WEST SUSSEX COUNTY COUNCIL CONSULTATION

TO:	Arun District Council FAO: Anita Gardner
FROM:	WSCC - Highways Authority
DATE:	24 June 2021
LOCATION:	Arundel Acre Arundel Road Angmering BN164EU
SUBJECT:	A/56/21/PL Change of Use of land from agricultural to storage site for up to 4 fairground rides, associated infrastructure (including MOT base) and erection of a storage shed. Amended certificate received. Updated swept path diagram JNY10317 -04 A
DATE OF SITE VISIT:	n/a
RECOMMENDATION:	No Objection
S106 CONTRIBUTION TOTAL:	n/a / £ See below for breakdown.

Plate 2: Recent Access Improvements – Hedgerow Trimming on A27

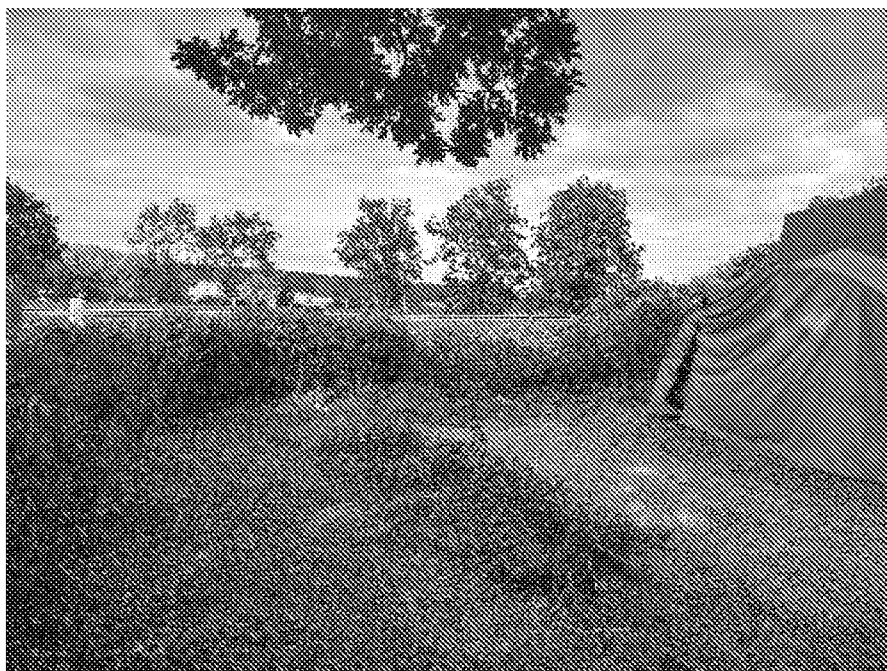
It is also acknowledged the applicant has been able to remove vegetation within their site boundary to the north, to improve this visibility splay, giving a better view of cars exiting the A27 travelling southbound.

JNY10317/04

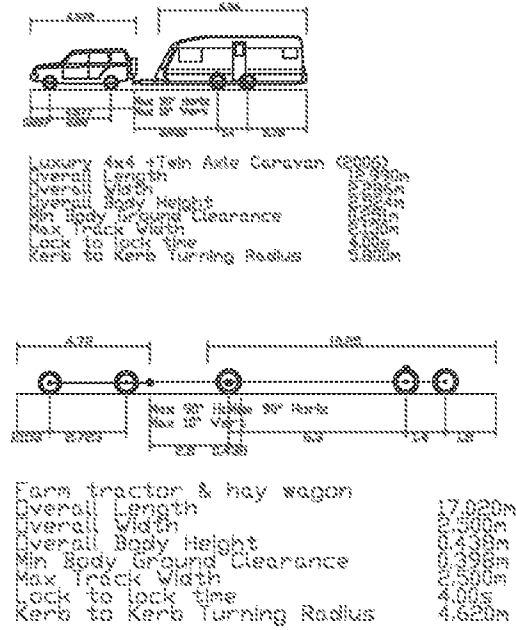
Plan JNY10317/04A shows the swept path of a car and caravan, and a farm tractor and hay wagon. These show both types of vehicle can enter and exit in forward gear, are able to make a turn on site and exit in forward gear. They are also able to pass the gates in situ freely.
